CITY OF ALBUQUERQUE

May 16, 2022

**Re: Façade Renovation
7100 Menaul Blvd. NE
Traffic Circulation Layout**
Architect's Stamp 03-28-22 (H19-D092)

**SITE PLAN**  
1" = 10'-0"

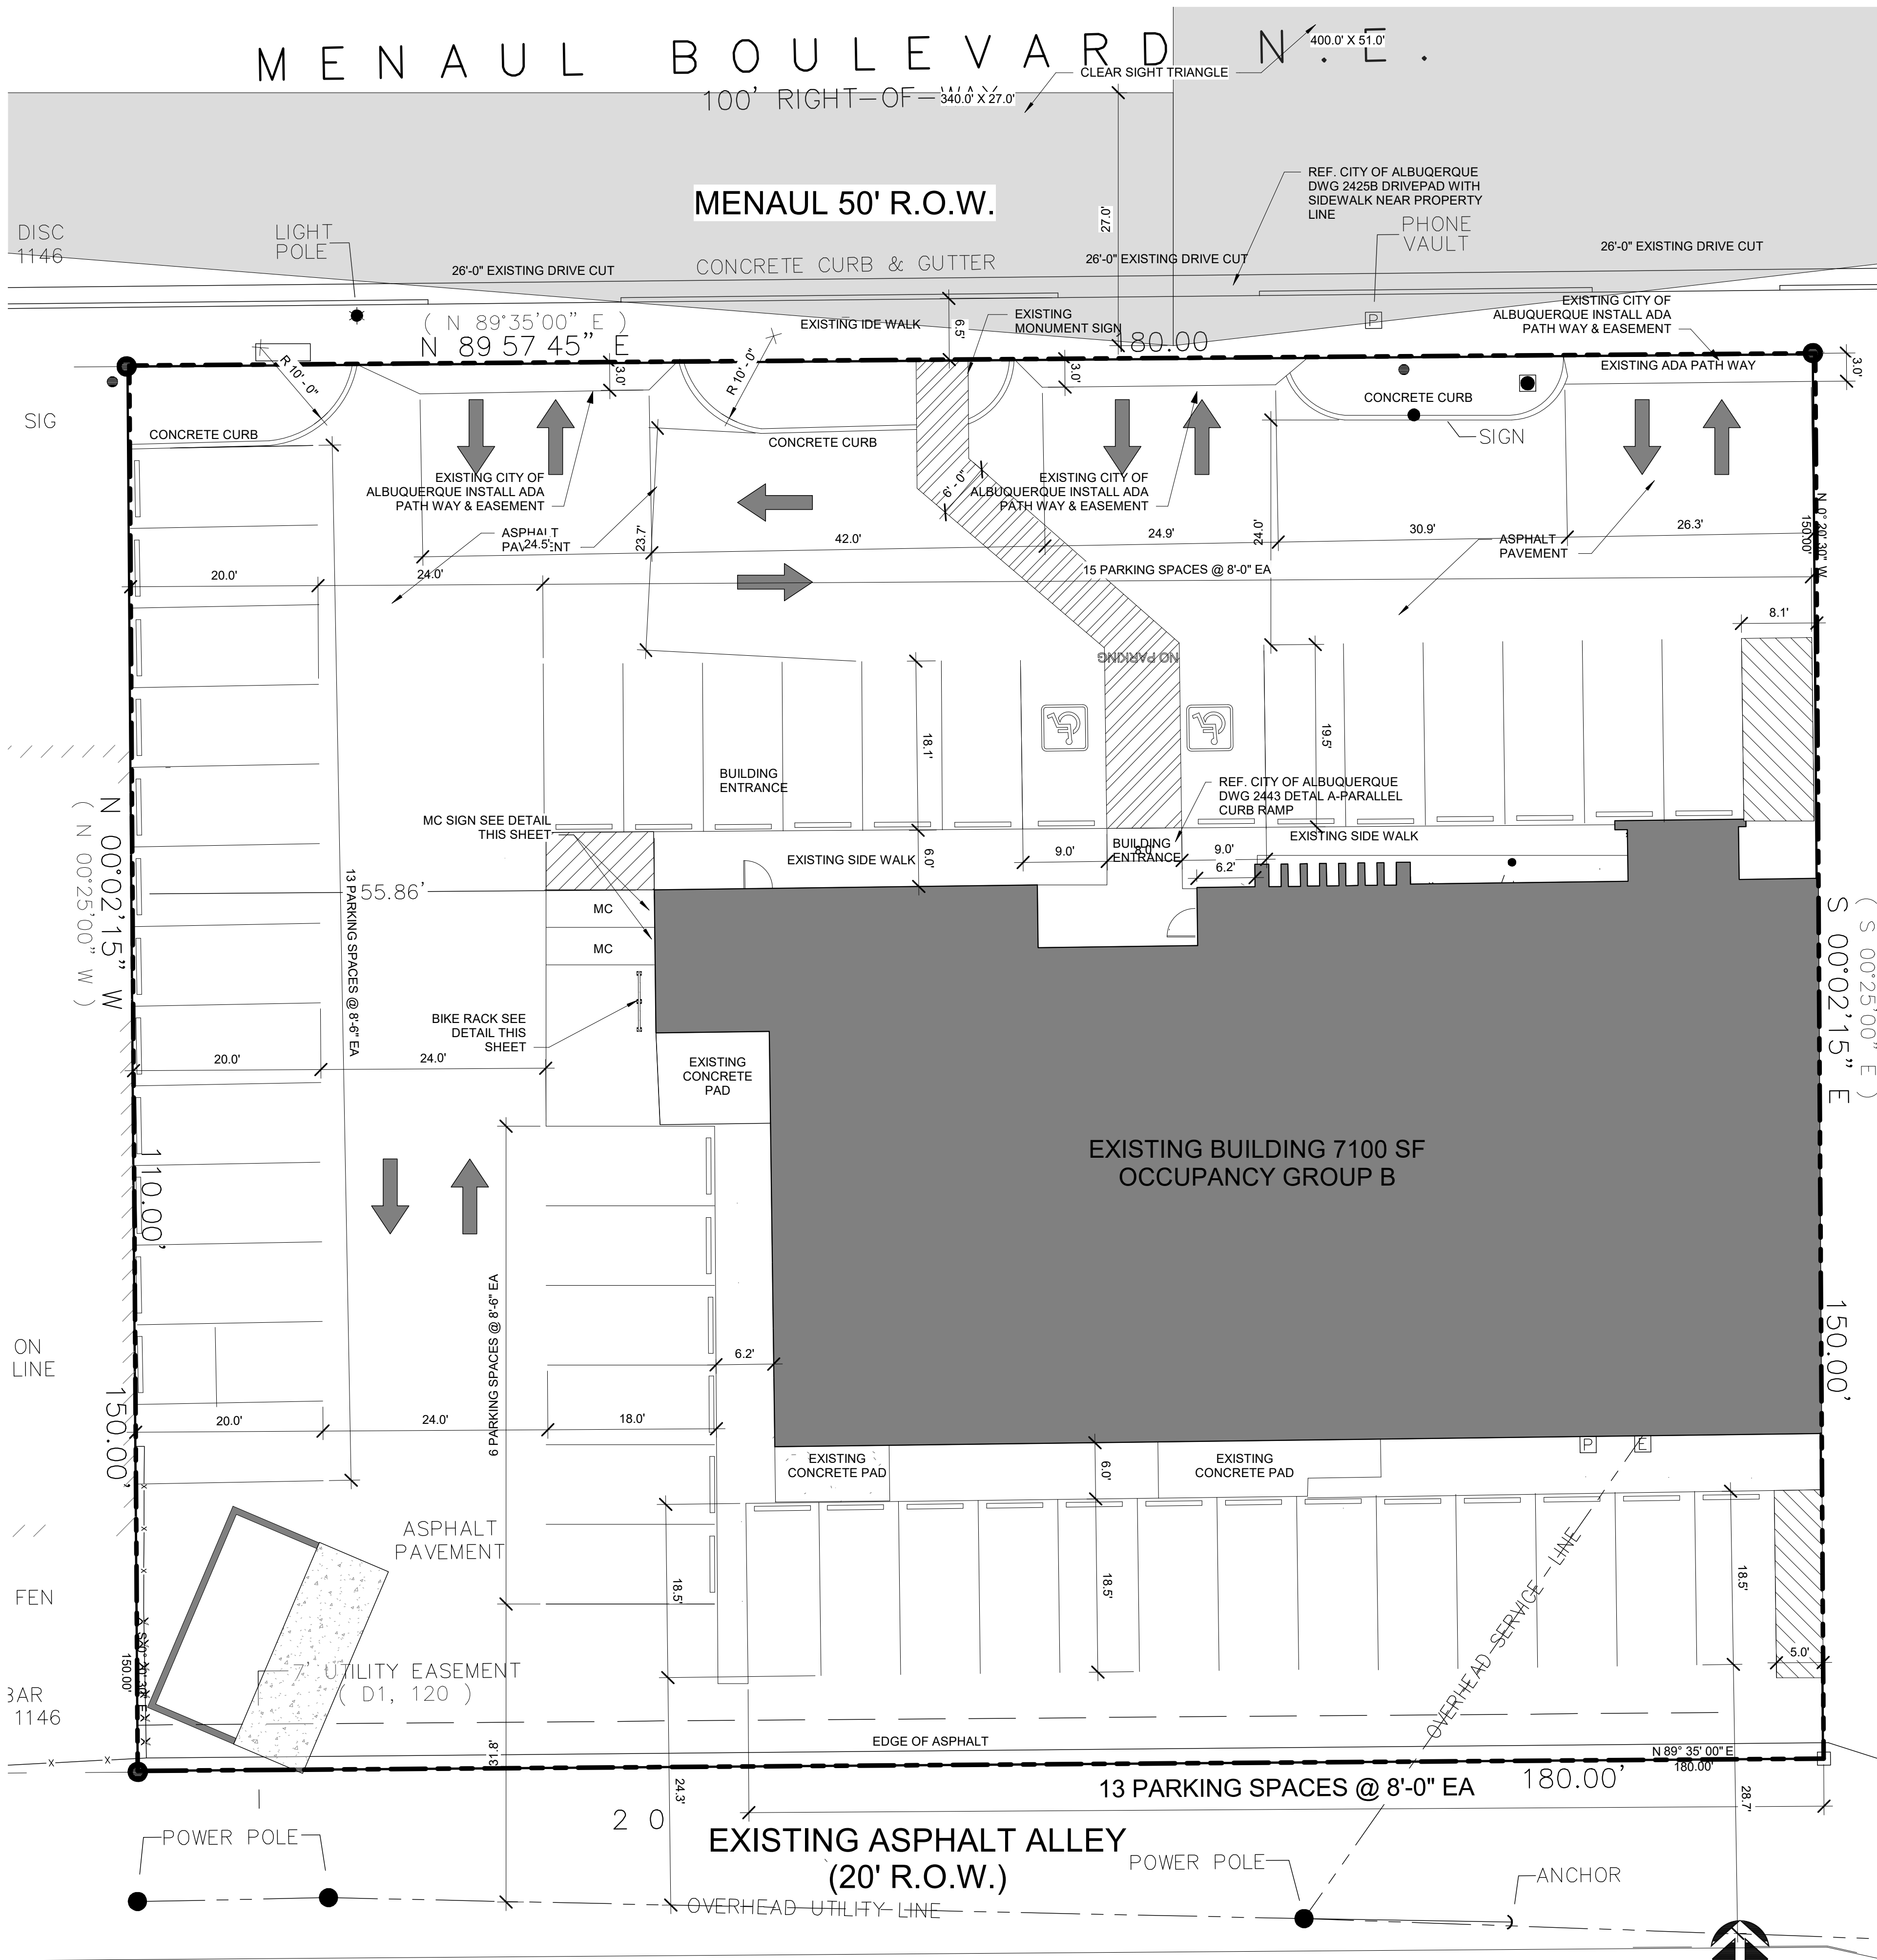
1. Please show a vicinity map showing the location of the development in relation to streets and well known landmarks.
2. Please clarify the current use of the building. And What is the proposing use?
3. Provide the width for the existing driveways, and the distance between them.
4. Provide the width for the existing sidewalk.
5. Maximum access width for arterial, collector, and local streets are as follows:

6. Please list the width and length for all existing and proposed parking spaces. Some dimensions are not shown.
7. The minimum parking stall dimensions are:

8. The ADA accessible spaces must include an access aisle. Van accessible aisles should be 8ft wide; all others should be 5ft wide.
9. ADA curb ramps must be updated to current standards and have truncated domes installed.

10. Please provide the Motorcycle parking spaces requirement number by the IDO, and show on site plan the Motorcycle parking space. Motorcycle parking spaces shall be designated by its own conspicuously posted upright sign, either free-standing or wall mounted per the zoning code. And provide MC pavement marking.

15. Show the width for the drive aisle at the south side of the site.
16. The minimum drive aisle dimensions are shown below

Minimum Drive Aisle Width
Two Way Traffic	22'
Main Circulation Road	24'
Fire Lane	20'
17. A 5 ft. keyway is required for dead-end parking aisles.
18. Show the building entrance on the site plan.
19. Per the IDO, a 6 ft. wide ADA accessible pedestrian pathway is required from the public sidewalk to the building entrances. Please clearly show this pathway and provide details.
20. Per DPM, a 6 ft. wide ADA accessible pedestrian pathway is required from the ADA parking stall access aisles to the building entrances. Please clearly show this pathway and provide details.
21. ADA accessible pedestrian pathway should not be placed behind parking space or adjacent to a vehicular way. Vehicle and pedestrian/wheel chair conflicts should be avoided as much as possible.

22. Clearly show if these pathways flush or if there any ramps have been provided. And provide ramps details.
23. Curbing should be installed to delineate landscape, parking, and pedestrian ways and identify points of access. Please call out detail and location of barrier curb.

24. Refuse vehicle maneuvering shall be contained on-site. The refuse vehicle shall not back into the public right of way.; provide a copy of refuse approval.

25. Please provide a sight distance exhibit
26. Show the clear Sight Distance triangle and add the following note to the plan:
"Landscaping and signage will not interfere with clear sight requirements. Therefore, signs, walls, trees, and shrubbery between 3 and 8 feet tall (as measured from the gutter pan) will not be acceptable in the clear sight triangle.

27. Please specify the City Standard Drawing Number when applicable.
28. Add a note stating "All broken or cracked sidewalk must be replaced with sidewalk and curb & gutter." A build note must be provided referring to the appropriate City Standard drawing.
